Re: Planning Application 20/0507

Address: Land South of Blackburn Road Hothersall PR3 2YY

Description: Outline Planning application for business units use classes B1(b)(c) and B2 and storage use class B8 and associated improvements to existing access with all matters reserved except for access.

Land south of Lower Road, Longridge – Indicative layout

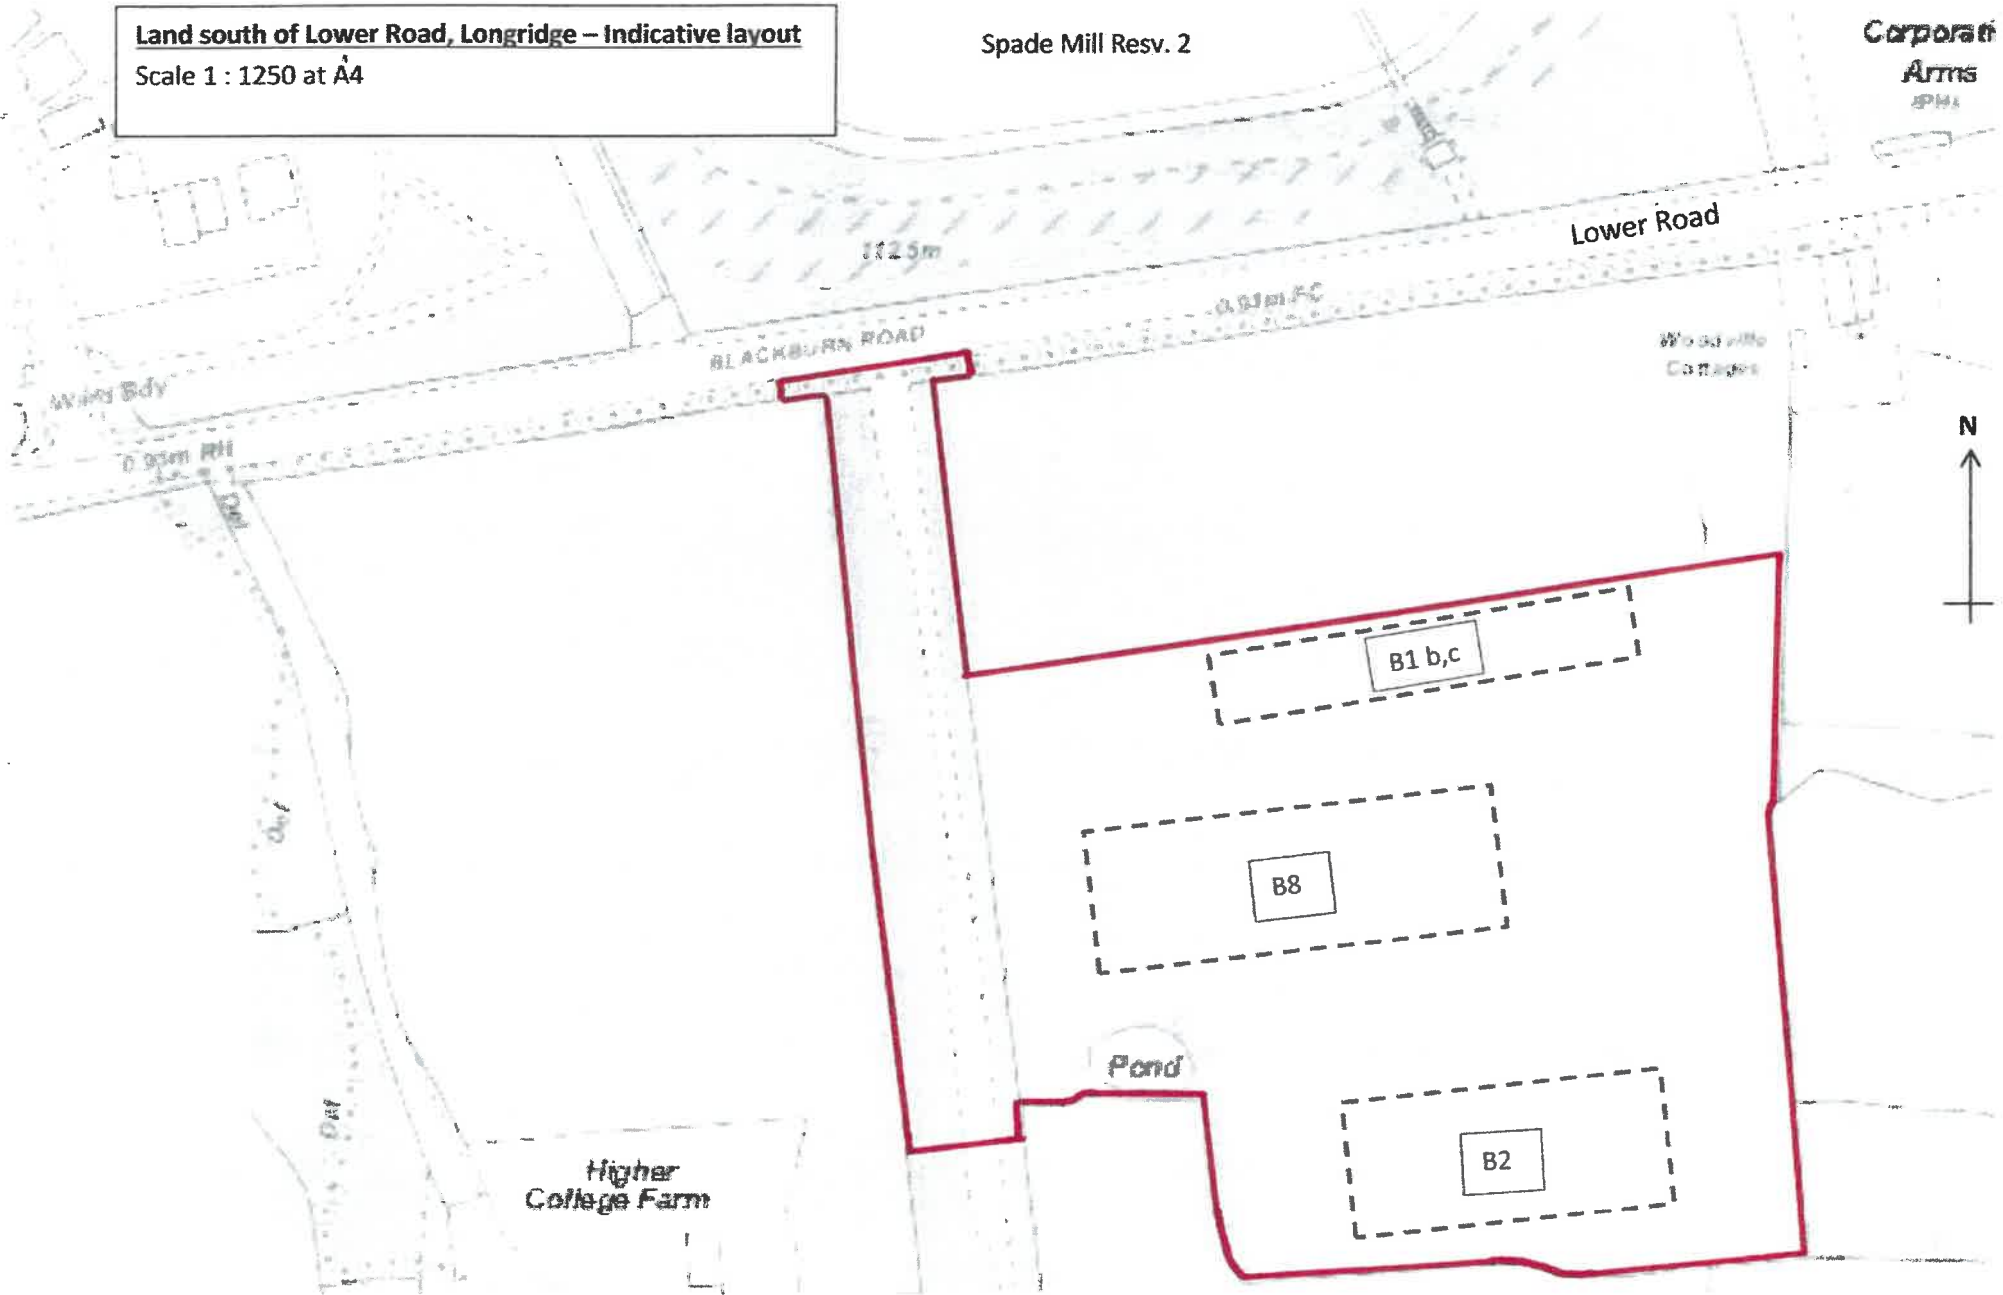
The current application includes a plan that will form the basis of a Section 278 agreement, this includes the re-configuration of radius kerbs and the provision of a footway from the site access to the bus stop opposite the Corporation Arms. This footway shall be adjacent to the kerbed edge of Blackburn Road and will be adopted for the section adjacent to the existing adopted highway. As part of the agreement the street lighting will need to be assessed to ensure it complies with current British Standards.

- Each individual premises regardless of their planning class shall be provided with at least one electric vehicle charging point
- A plan showing the parking provision as detailed in the application form shall be provided
- A further plan showing the access to the site from Blackburn Road and the provision of a pedestrian footway
- A comprehensive construction management plan including mechanical street sweeping should it be required.

3. No part of the development hereby approved shall commence until a scheme for the construction of the site access and the off-site works of highway improvement has been submitted to, approved by, the Local Planning Authority in consultation with the Highway Authority as part of a section 278 agreement, under the Highways Act 1980 and these works shall be completed prior to the trading or occupation of any element of the development. **Reasons:** In order to satisfy the Local Planning and Highway Authorities that the final details of the highway scheme/works are acceptable before work commences on site and to enable all construction traffic to enter and leave the premises in a safe manner without causing a hazard to other road users.
